Grading and Erosion Control Plan_V1 REDLINES.pdf Markup Summary

DRAWN BY: O.E. WATTS		APPROVED BY:		REVISIONS 8-16-21 UPDATED		DEW		OLIVER E. WATTS		PROJECT		SHT. NO.	
DATE: 12-30-21		PROJ. NO. 19-5341-03		12-30-21 REVISED PER COUNTY REVIEW COMMENTS		DEW		CONSULTING ENGINEER		ROCKY TOP MOTEL & CAMPGROUND		1	
DWG. NO. 19-5341-03		DWG.						COLORADO SPRINGS		PART NW1/4 SECTION 9, T.13S., R.68W., 6TH P.M.		OF	
TOPOGRAPHY BY: CITY FMS 6-12-19										EL PASO COUNTY		3	
SURVEY INFORMATION BY: RAMPART JOB NO. 18384										GRADING AND EROSION CONTROL PLAN

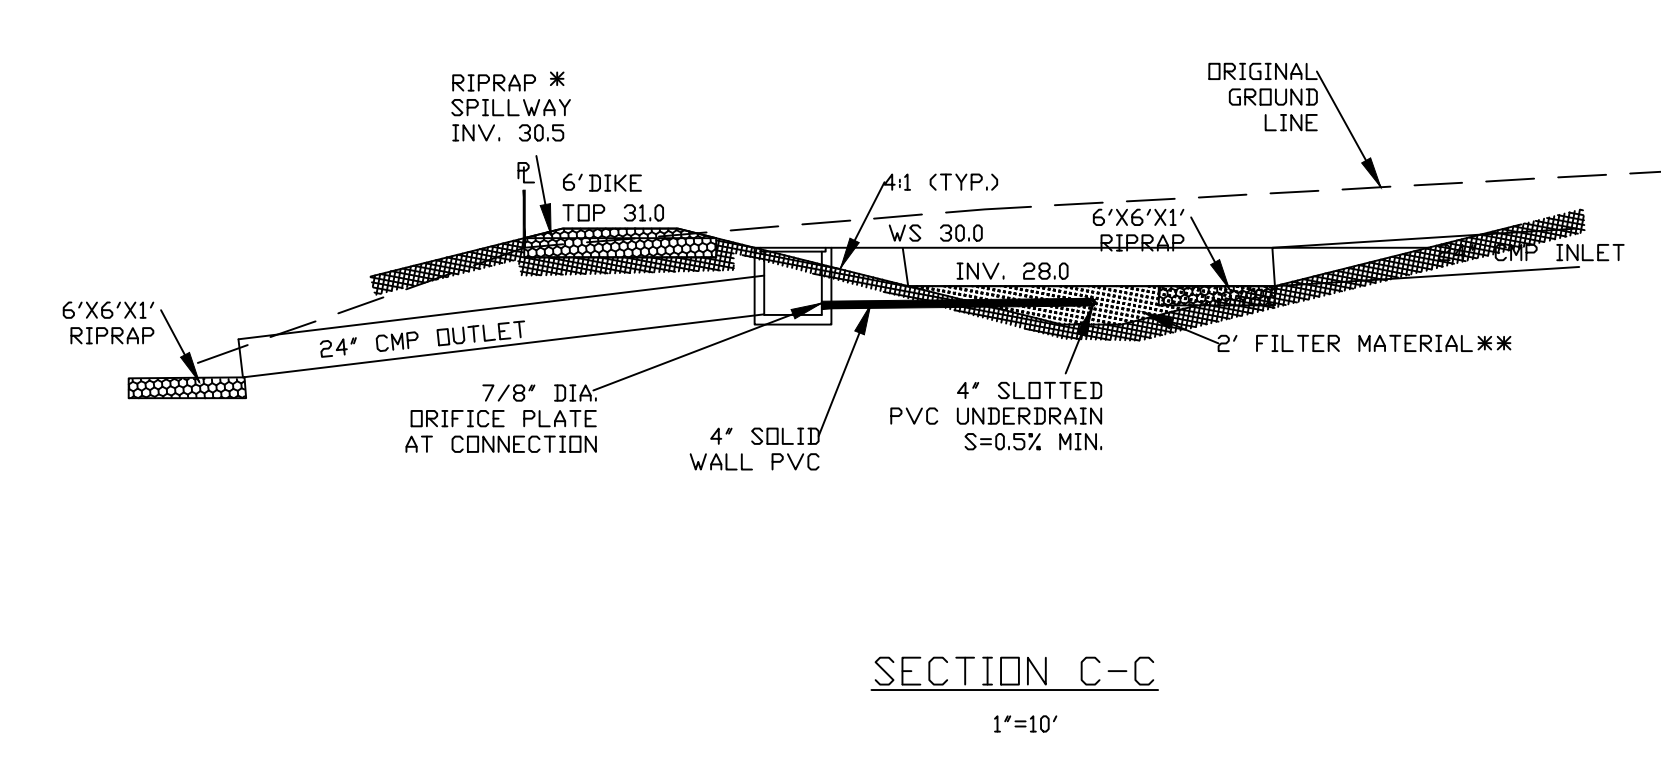
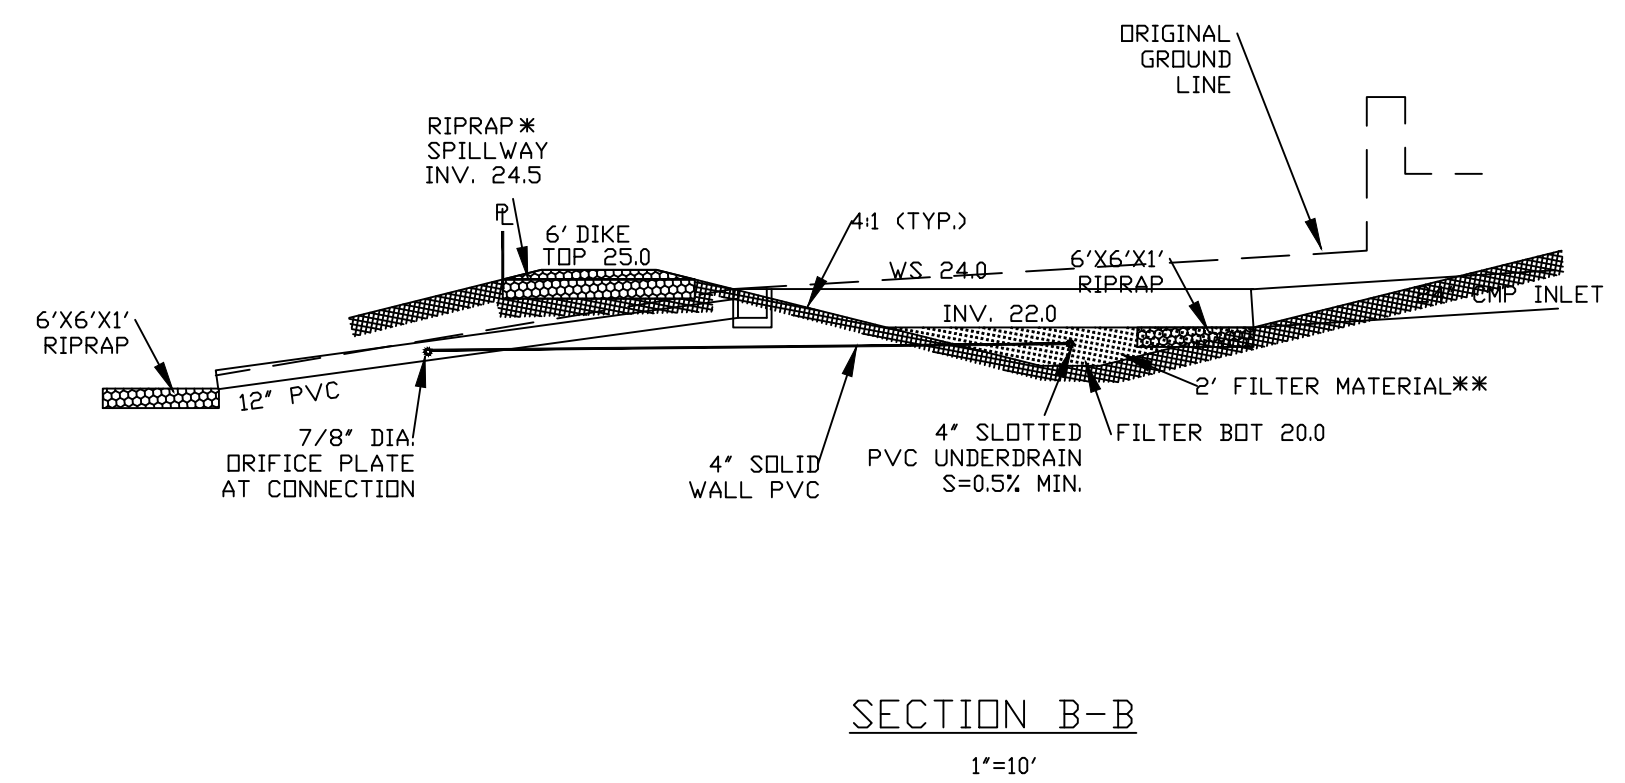
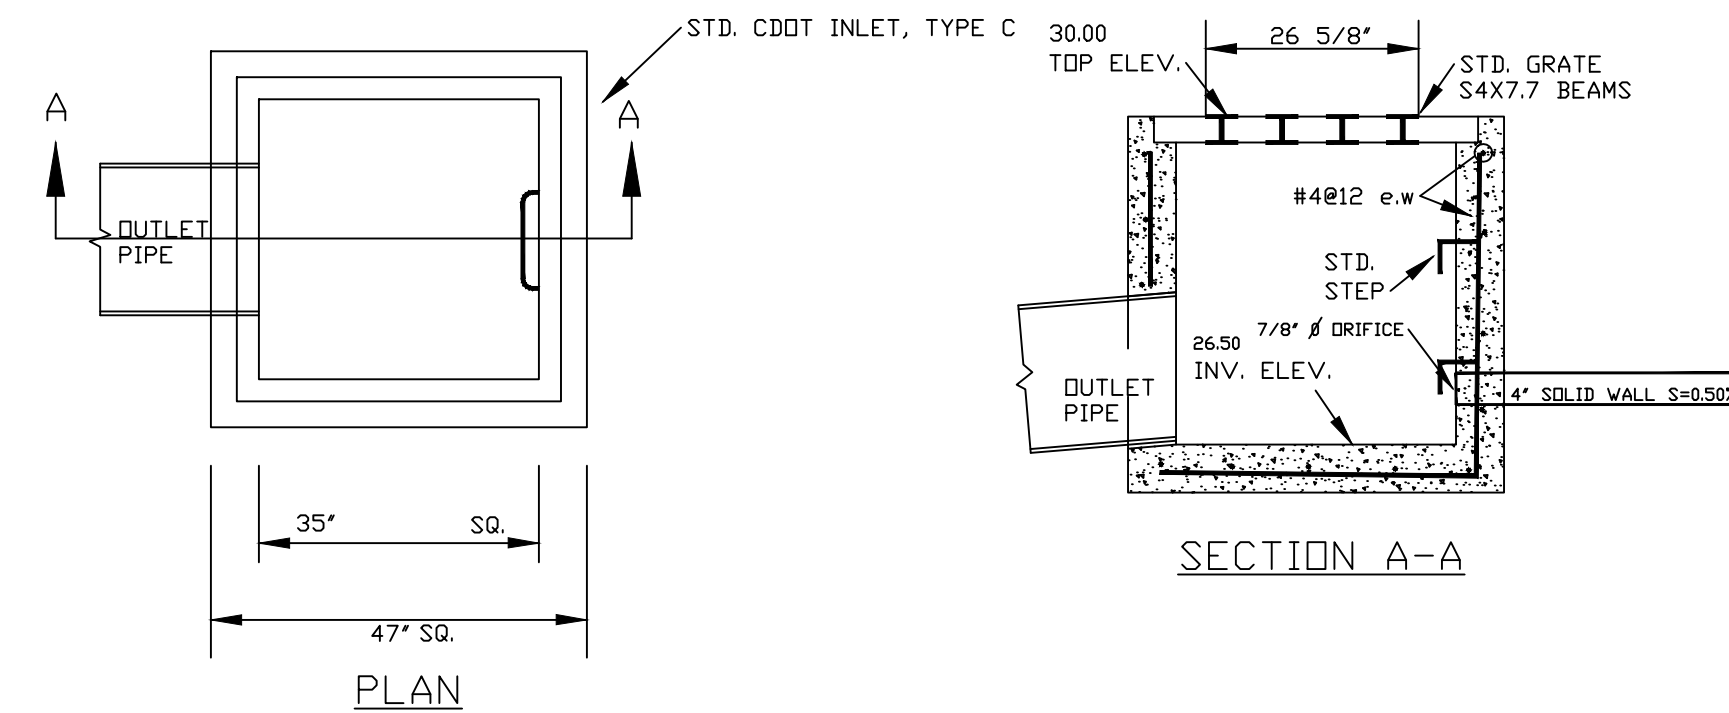
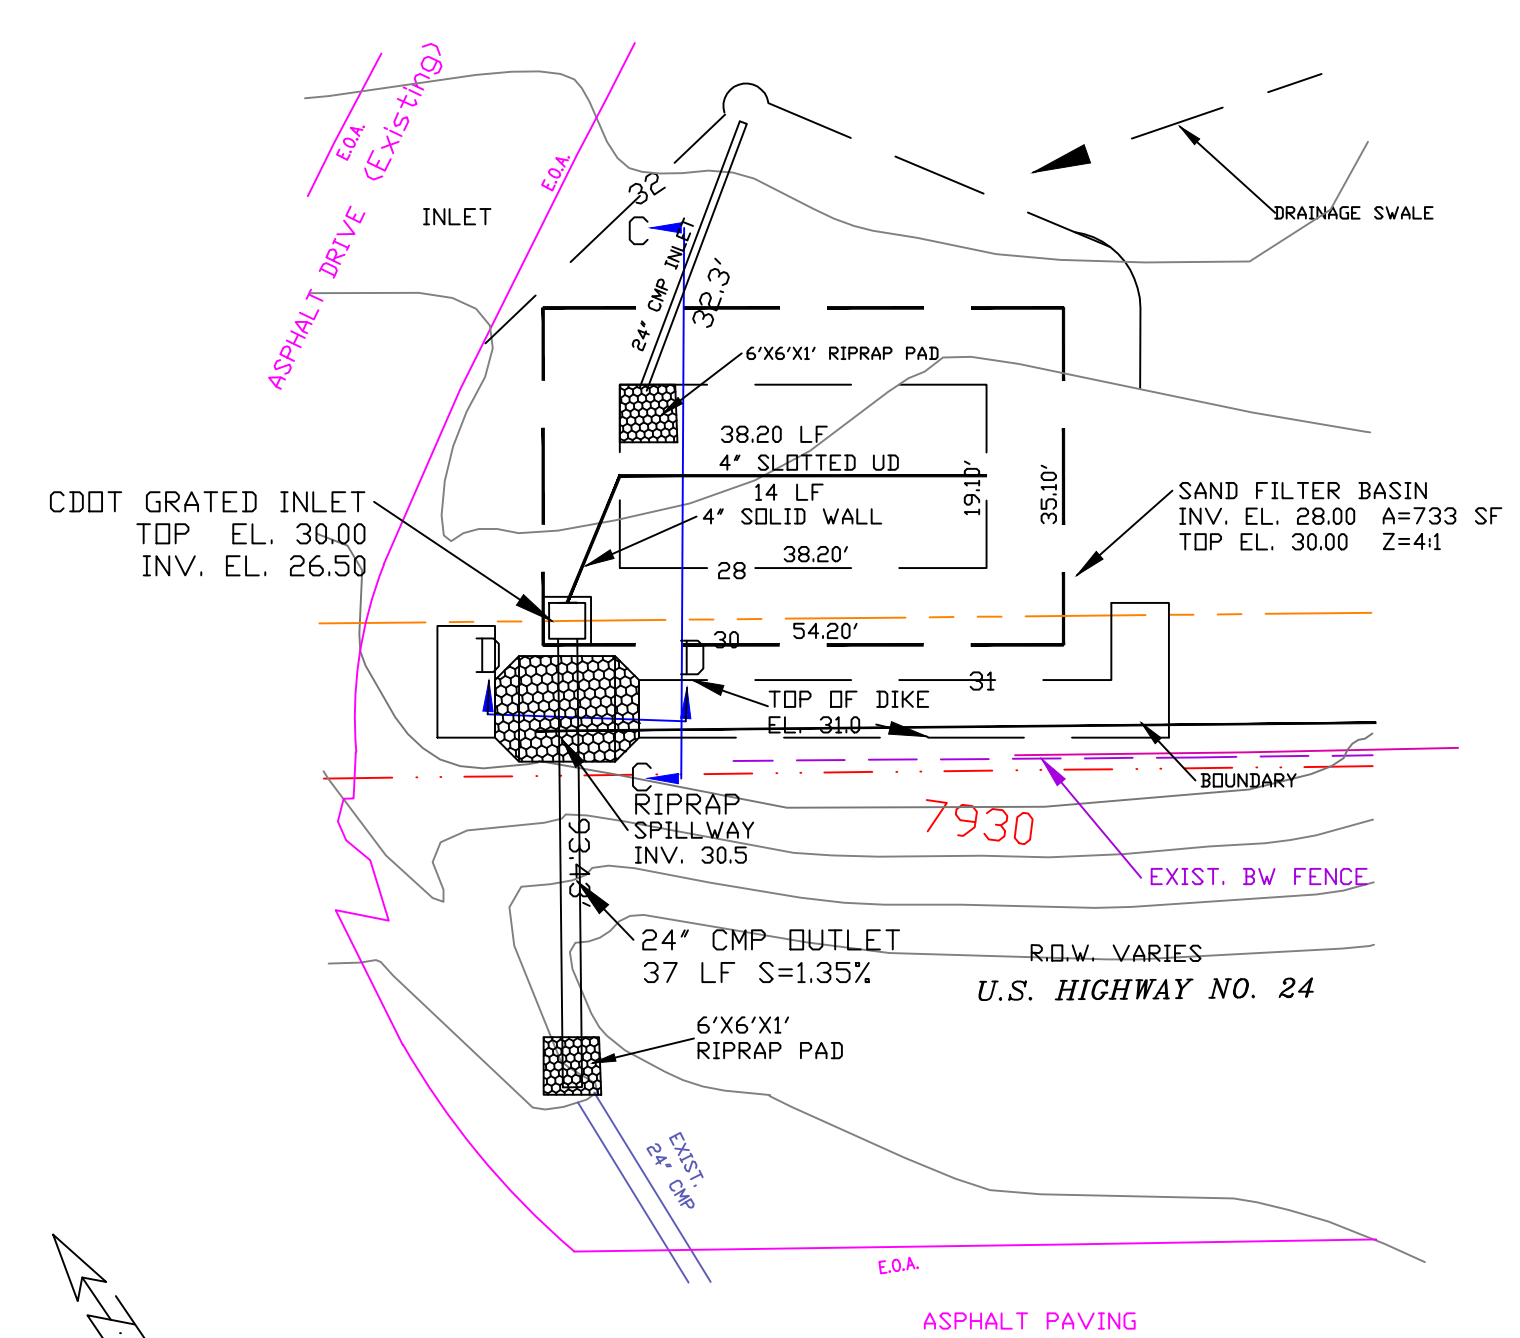
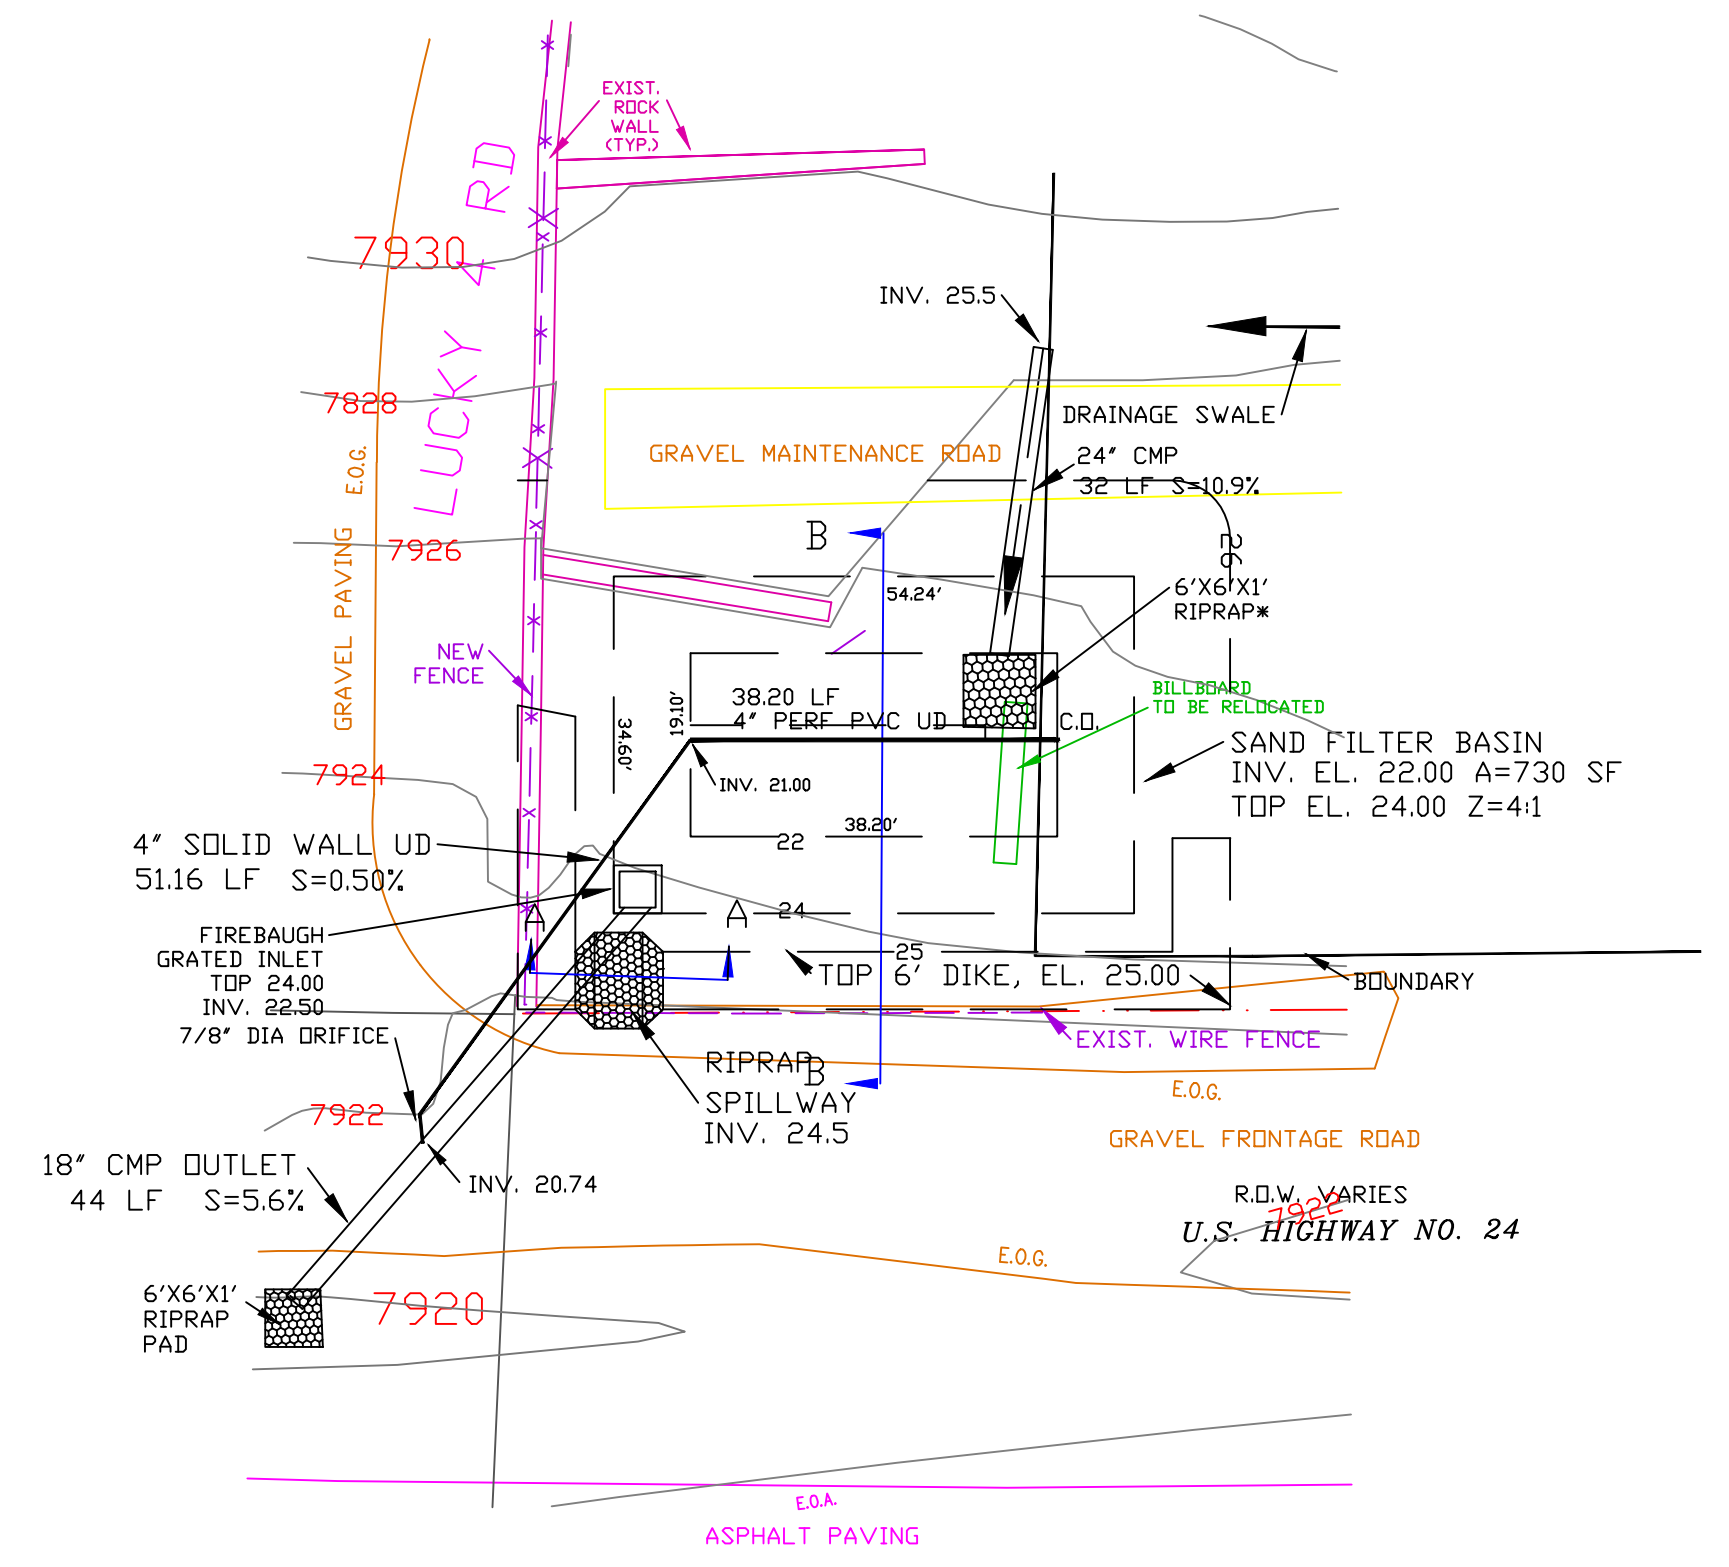
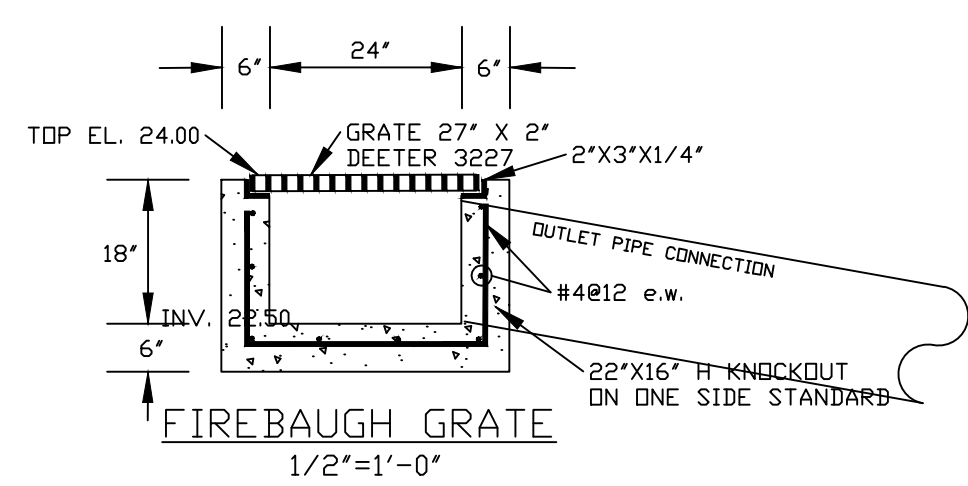
Review 1 comment: Please label and show the recently installed retaining walls and provide the resulting contours after the installation of the retaining wall.
Review 2: Unresolved. Please address the above and label the retaining walls. It does not appear that the contours shown match the current conditions in this area
Review 3: unresolved.

Show location and details for spillway, outlet structure, cleanout pipe, maintenance access road,

provide area for East pond too.

linework connecting limits of disturbance has disappeared. And compared to the last submittal, the lines aren't just being covered by the newly add retaining wall red lines.

Is this dashed black line supposed to be part of the LOD too?

Unresolved comment from Review #2:
Consider moving access to be through the gravel parking area north of here (per the path shown with the orange arrows) so that a VTC is not necessary. Otherwise this VTC will need to be within the LOD.

Unresolved comment from Review #2:
SP's and SSA's should be within the LOD.

Unresolved comment from Review #2:
SP's and SSA's should be within the LOD.

Unresolved comment from Review #2:
show BMPs to treat runoff from this area.

Unresolved comment from Review #2:
BMPs should protect downstream areas from sediment from the whole area of disturbance. This SF is only adjacent to the garage. Add BMPs to treat runoff from the rest of this area of disturbance.

It appears that this area outlined in red is the only area tributary to the silt fence. The area of disturbance just north of here will run across the asphalt road and bypass any BMPs. Add BMPs to treat that area of disturbance.

Unresolved comment from Review #2:
show BMPs to treat runoff from this area (silt fence, sediment basin, etc)

This newly added swale needs to be shown within the LOD.

Show location of newly added runoff reduction (RR) area. The RR area is discussed in the Drainage Report text and calculations were provided but the limits of that area are not delineated anywhere.

Provide dimensions of bottom of sand filters.

show inlet piping and riprap that is shown on drainage report's map.

Label the angle of the underdrain, otherwise contractor will not know your intention/ design with the angled pipe.

All grading must be included within the LOD.

Revise arrows per latest revisions to contours (ie: addition of the swale). There should be an arrow pointing along the swale towards the pond
